Title Planning application 3/2022/0553 – Land south of Lower Road Longridge - Objections

Planning Application No: 3/2022/0553

Proposal: Proposed erection of mixed-use commercial units and storage facilities and conversion of a farmhouse.

Location: Higher College Farm Lower Road Longridge PR3 2YY

## **Appendix B – Proposed Access Plan (as previously approved)**

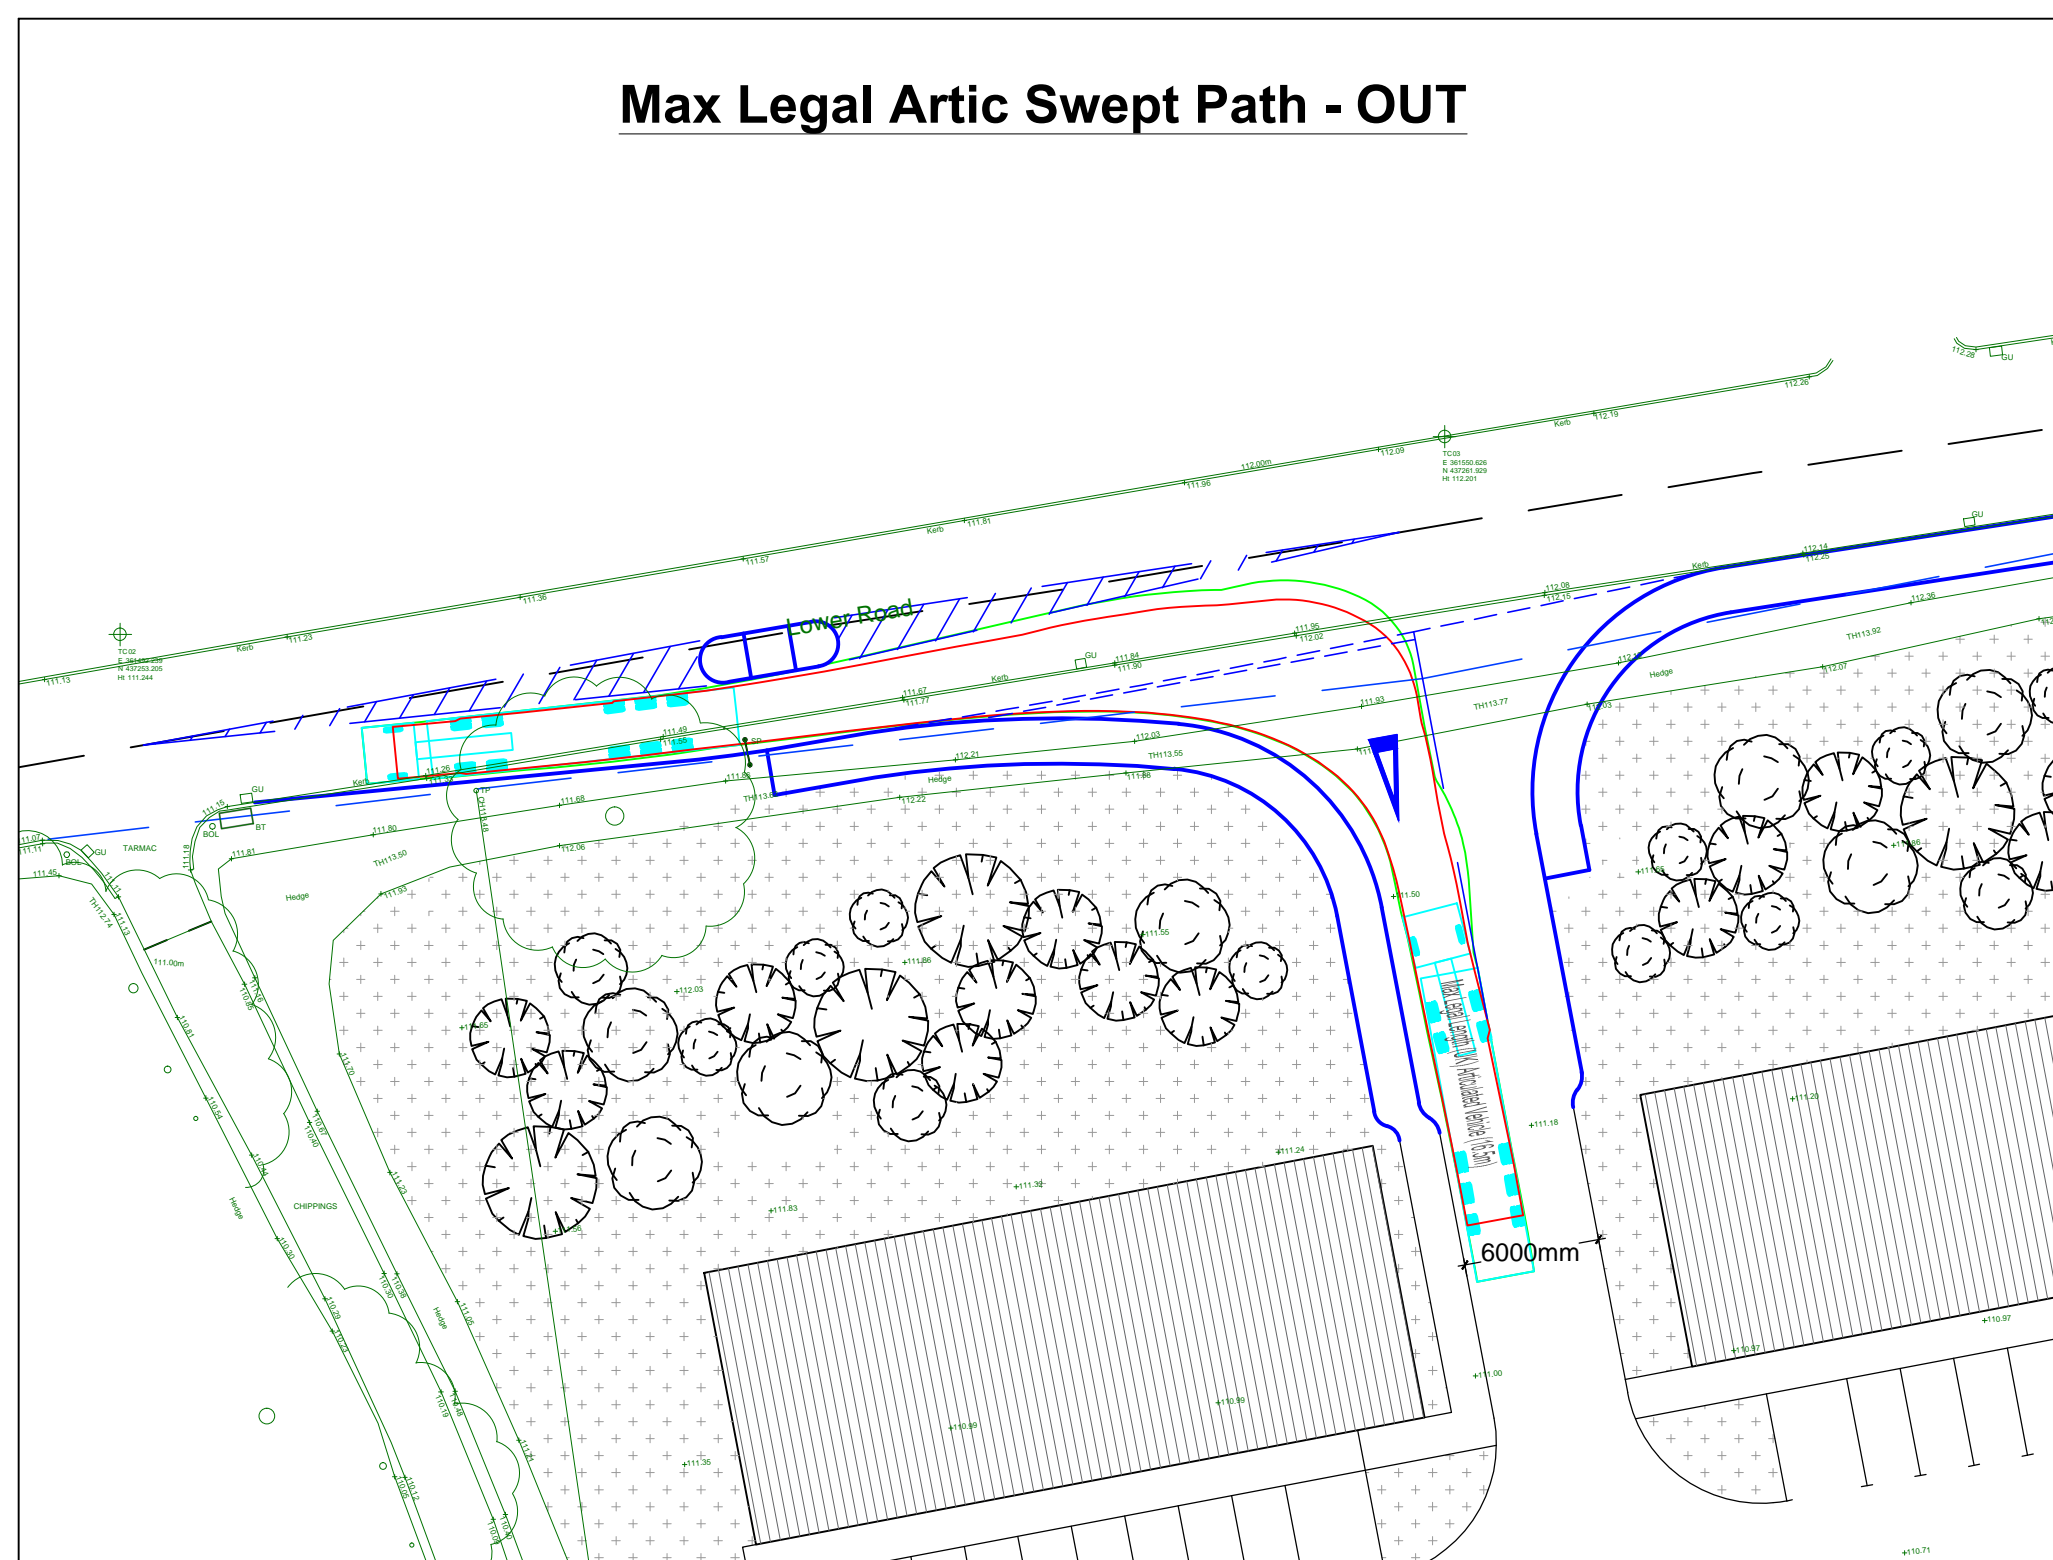
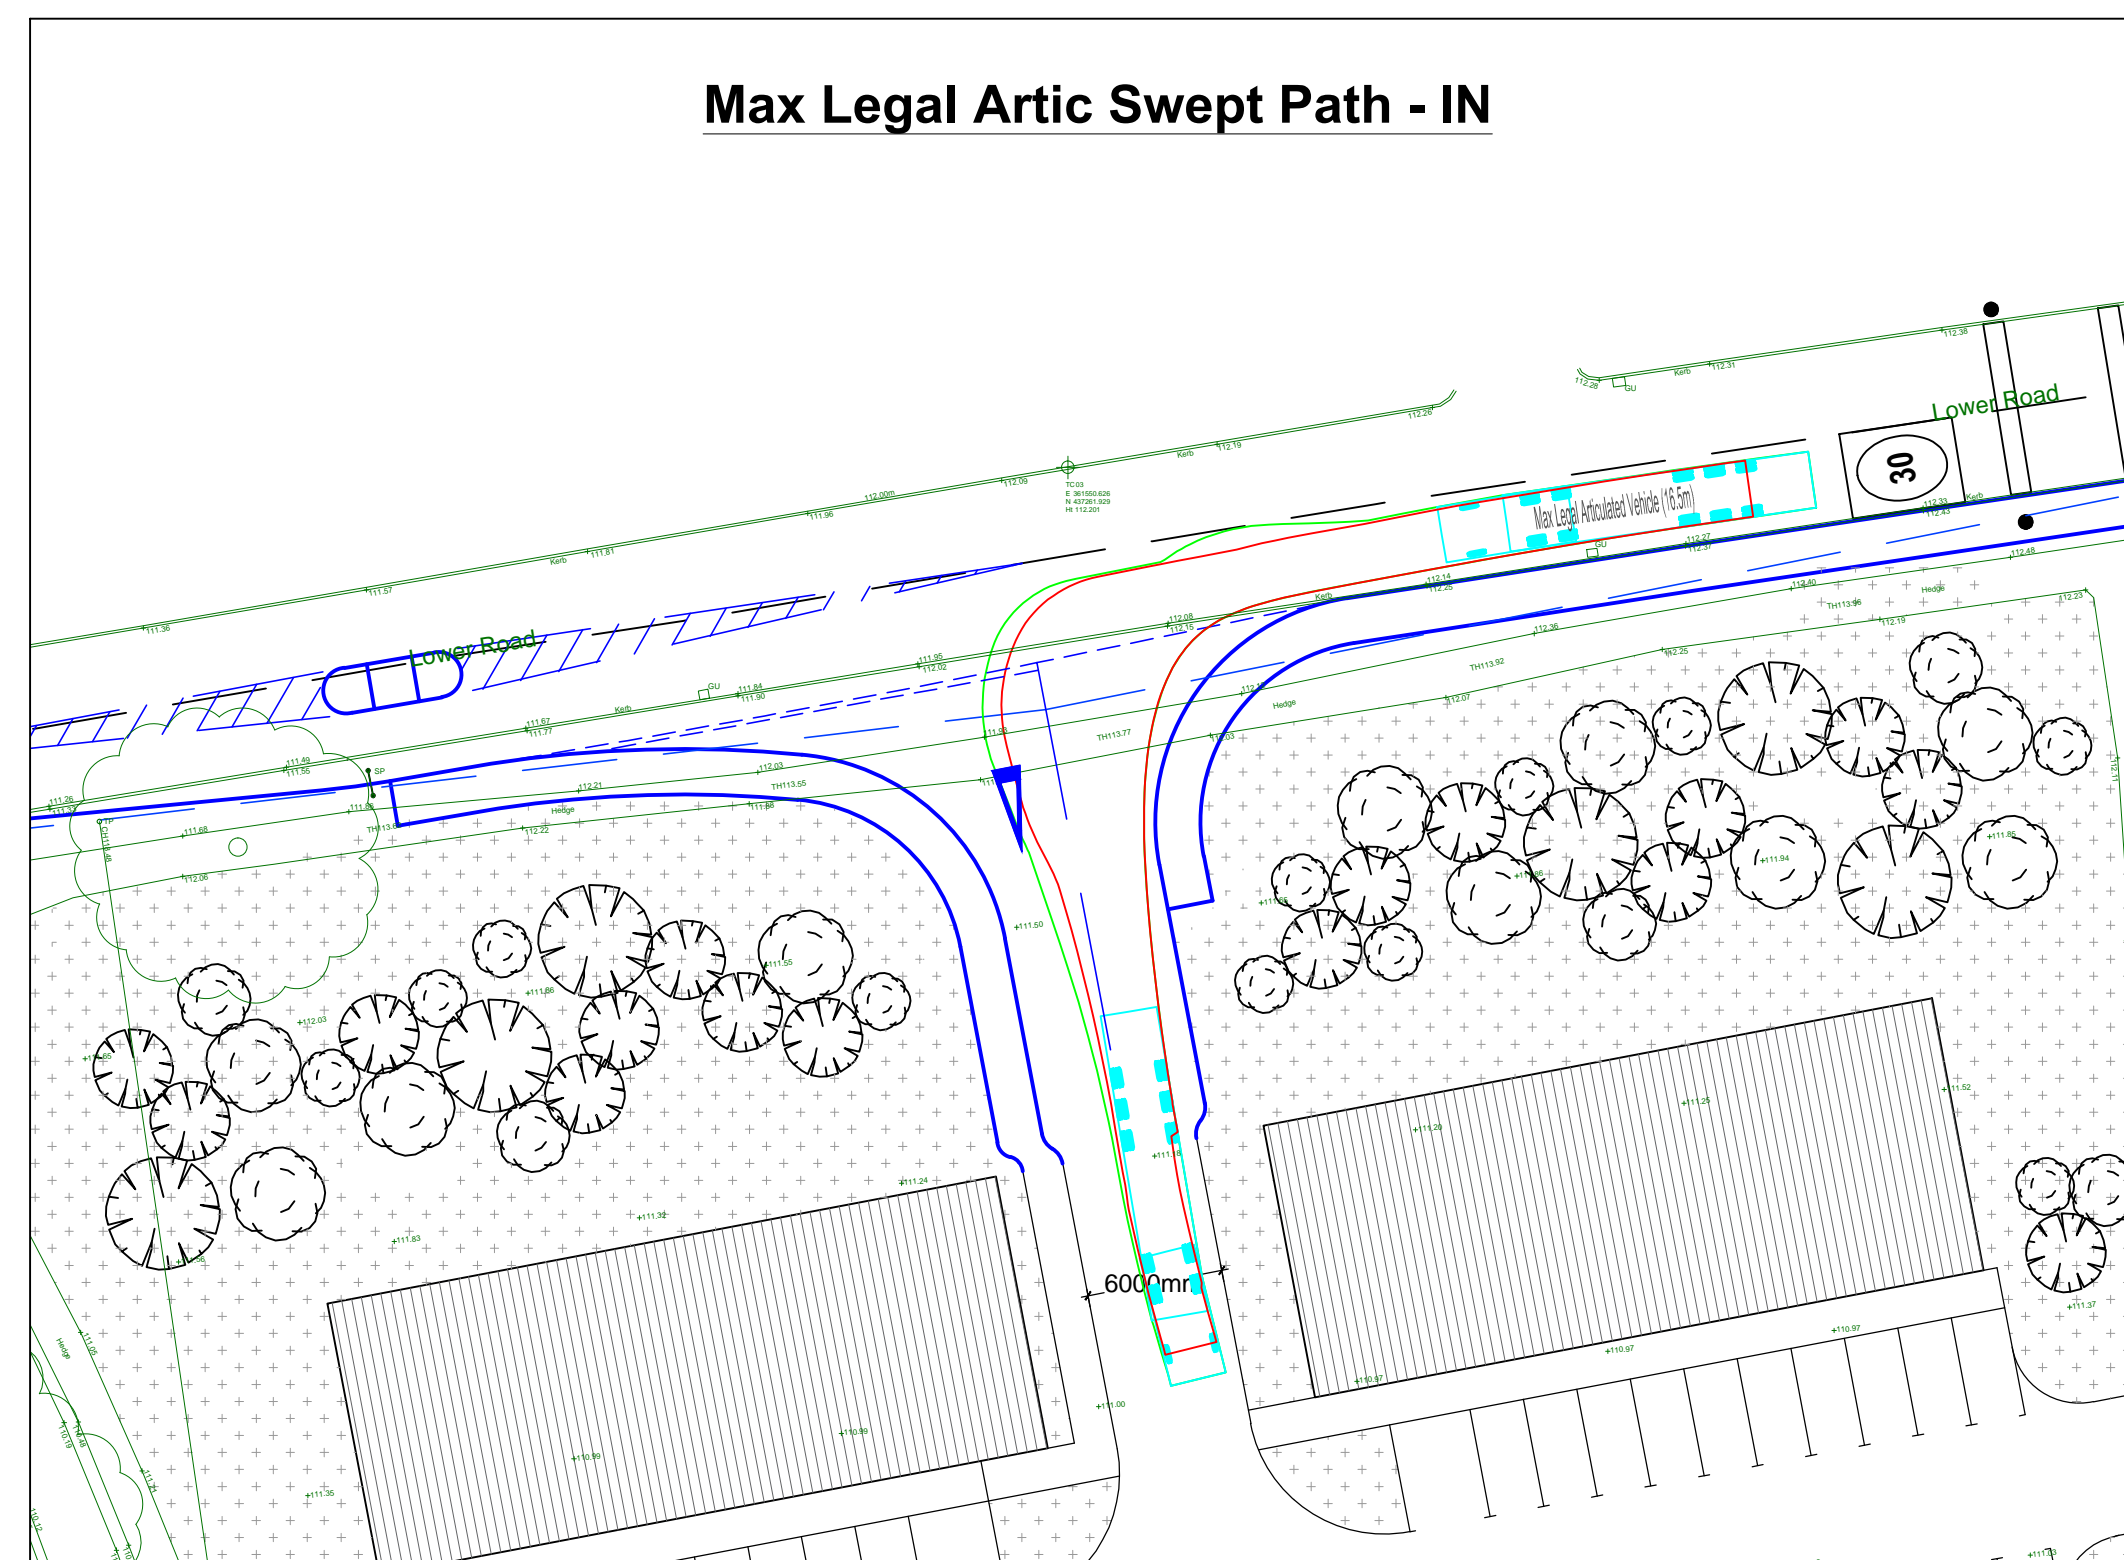
The max legal artic swept paths will be exceeded. I.e. How far HGVs pass across the carriageways of the road as they turn.

Note that the HGVs of [REDACTED] completely break the max legal swept paths as I understand them, by going right across both lanes of the road, and should not have been permitted in the first place.

**A planning application for industrial units back in the 2000's (2006?) was actually turned down by the LCC Roads Engineer because he considered the highway entrance unsafe! It is far more dangerous now with the greater traffic volumes and a new housing estate right beside it!**
